**Hills Showground Station Precinct (SSD-9653)
Request for Additional Information**

I refer to the above Concept Application (SSD 9653) and the Department's previous correspondence requesting a response to submissions, dated 19 December 2019.

Date	29.10.2019	Drawn	DH	Checked	SA	Approved	LA
CAD File						Revision	
Drawing Number							
SK 11

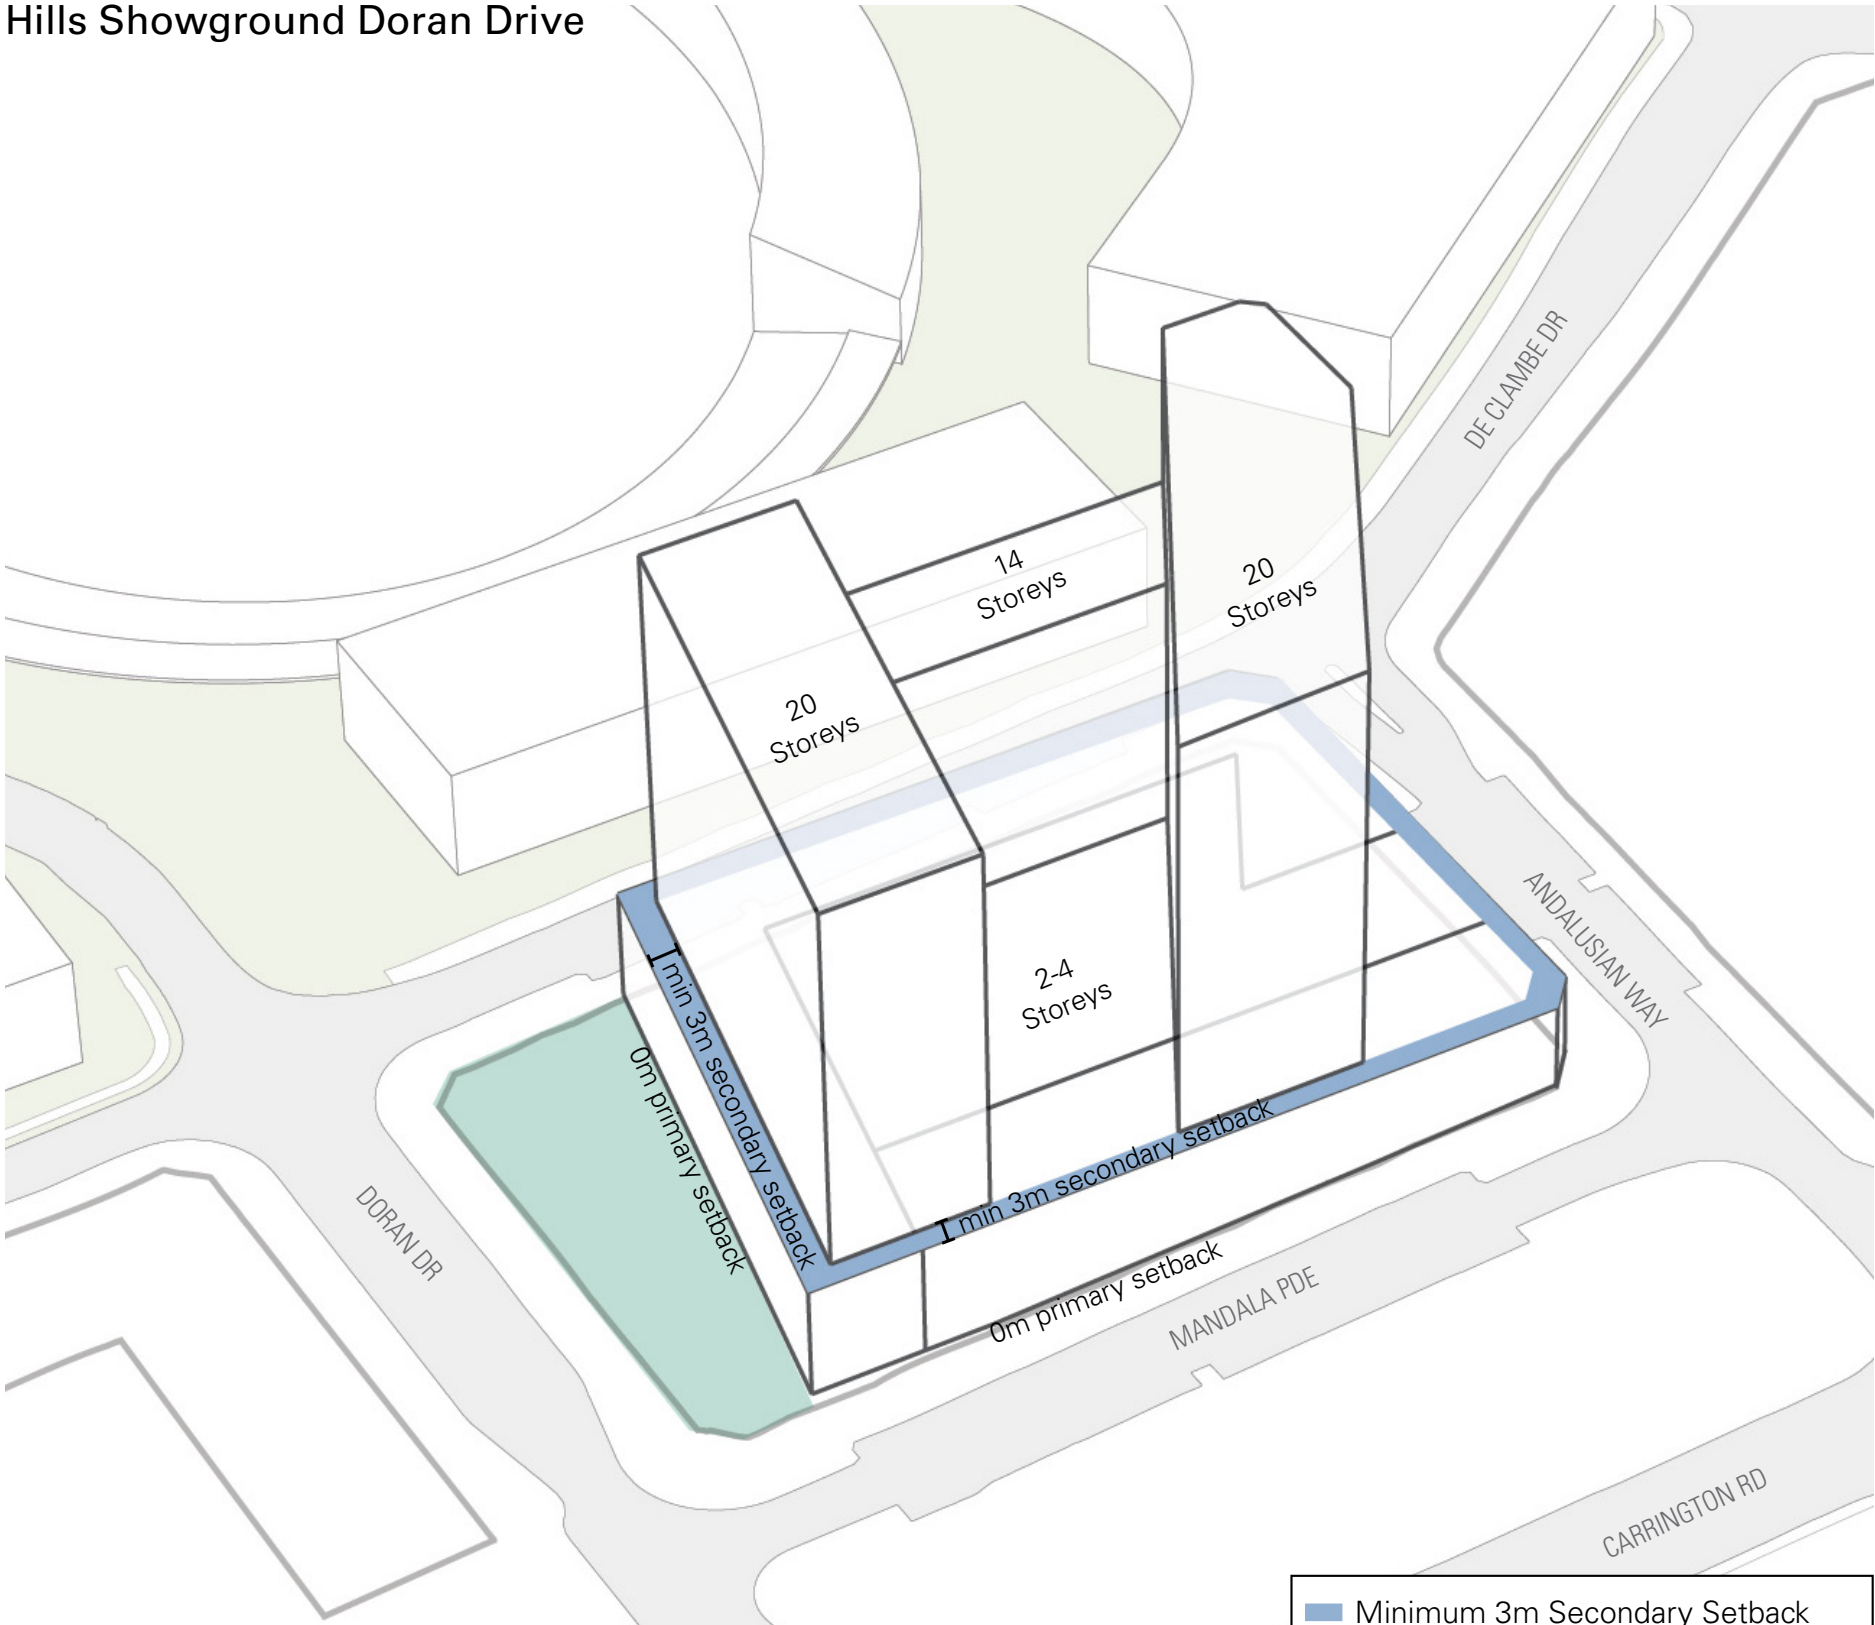
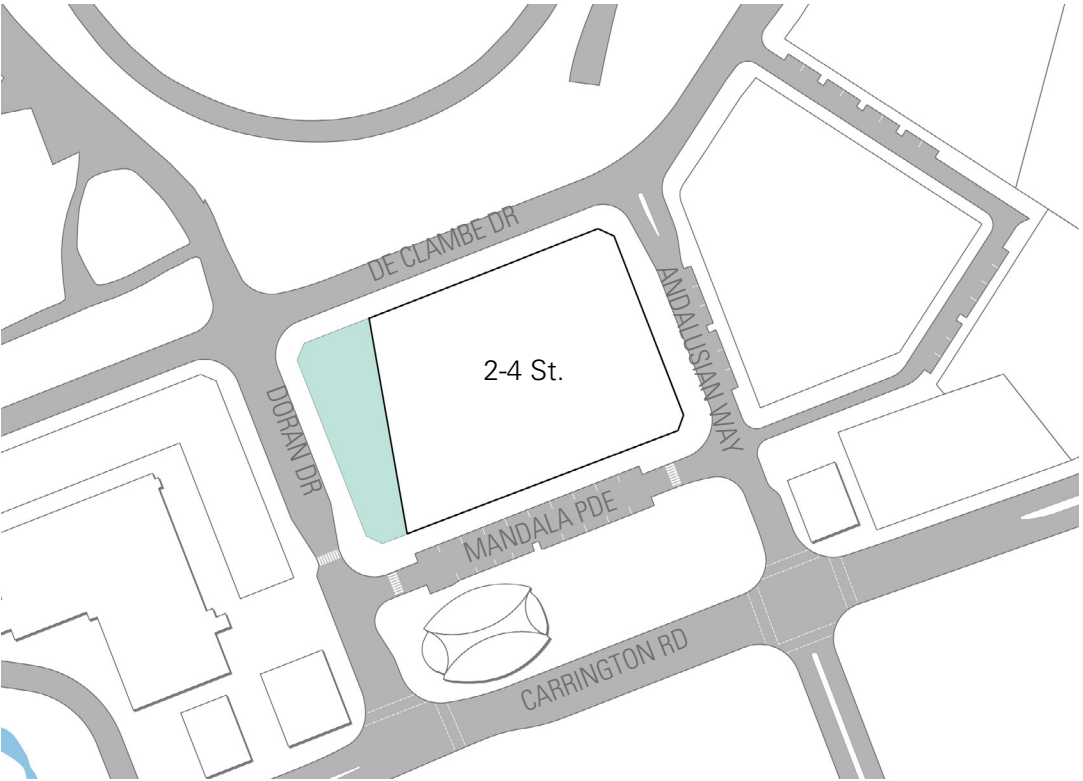
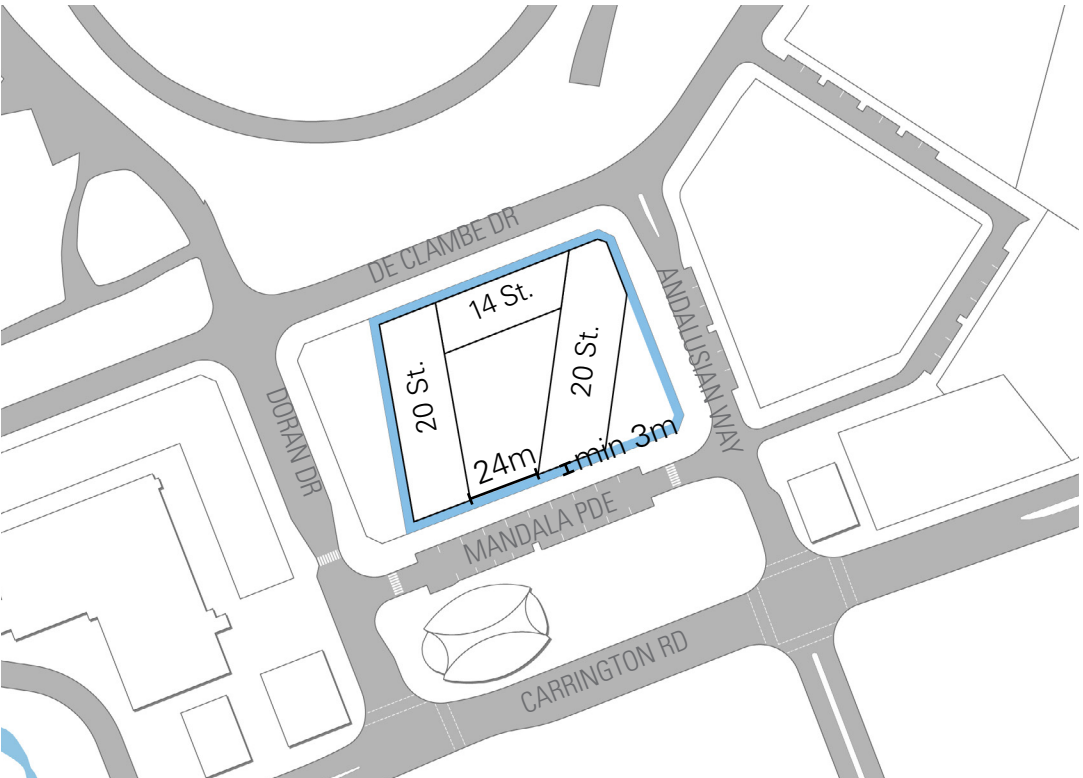
- i. Revise the proposed building envelopes to achieve improved amenity and compliance with the Apartment Design Guide (ADG). This may require a reduction or redistribution of the proposed building mass and density.

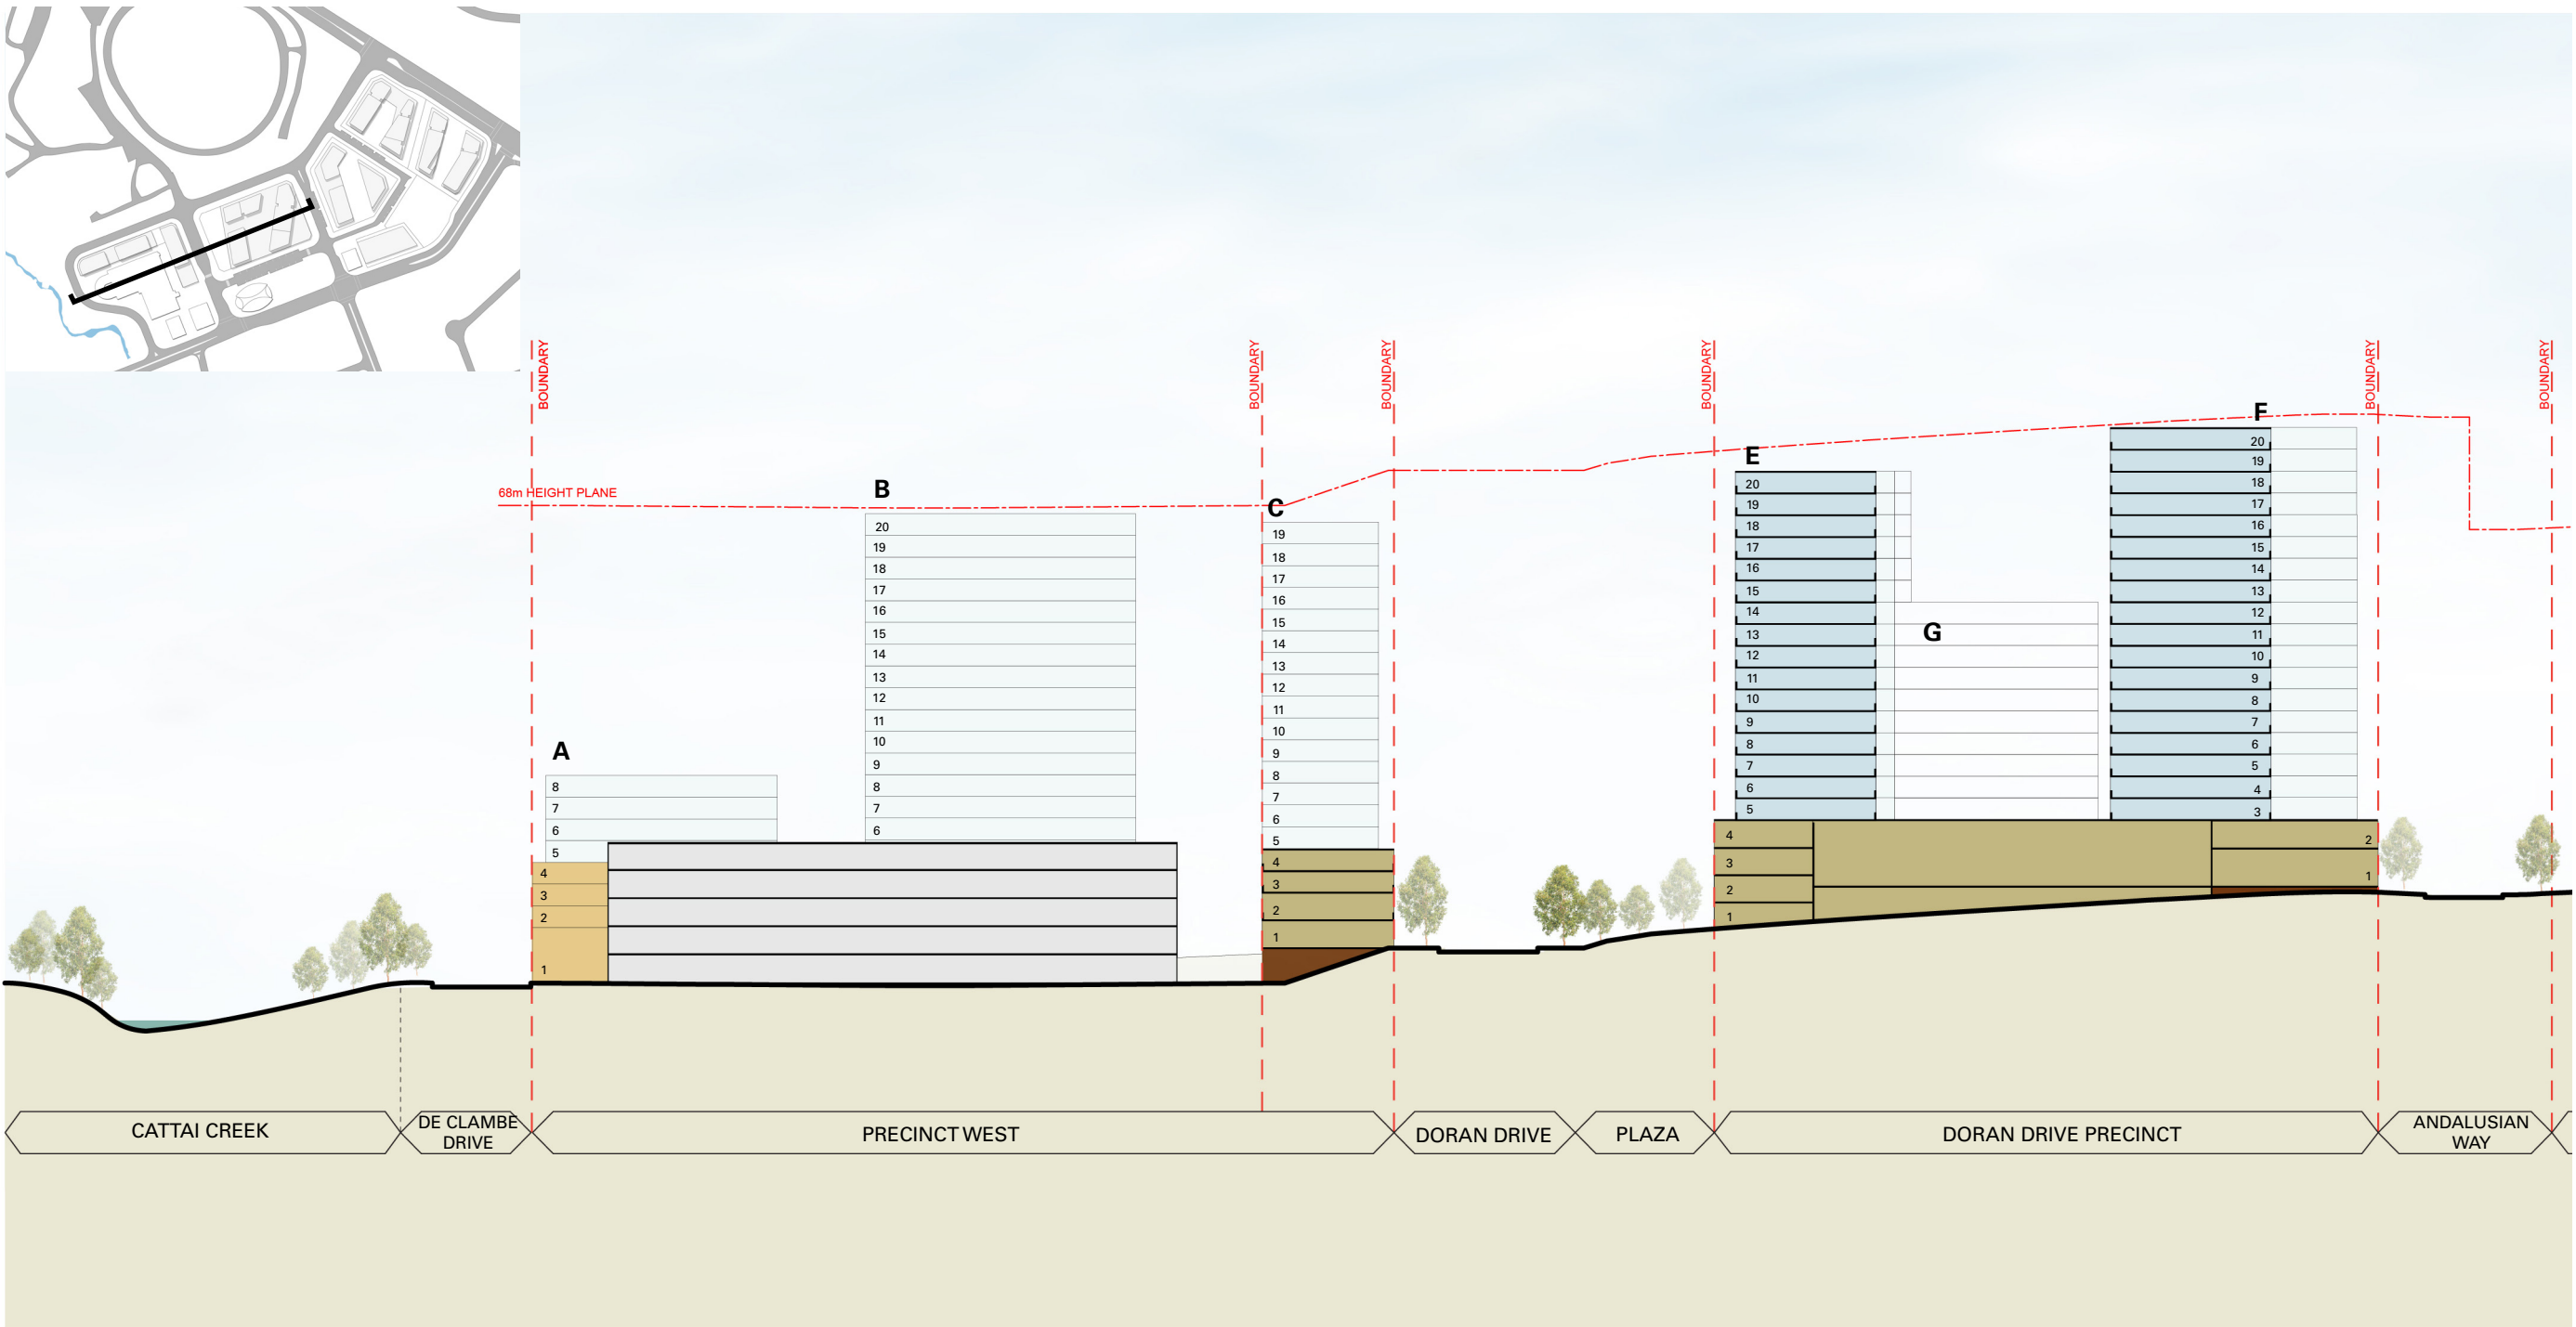
- vi. Review and clarify the discrepancies between the built form depicted in the Urban Design Report and submitted plans (Note: p. 91 Urban Design Report and SK 07 & SK 17 Plans for Approval).
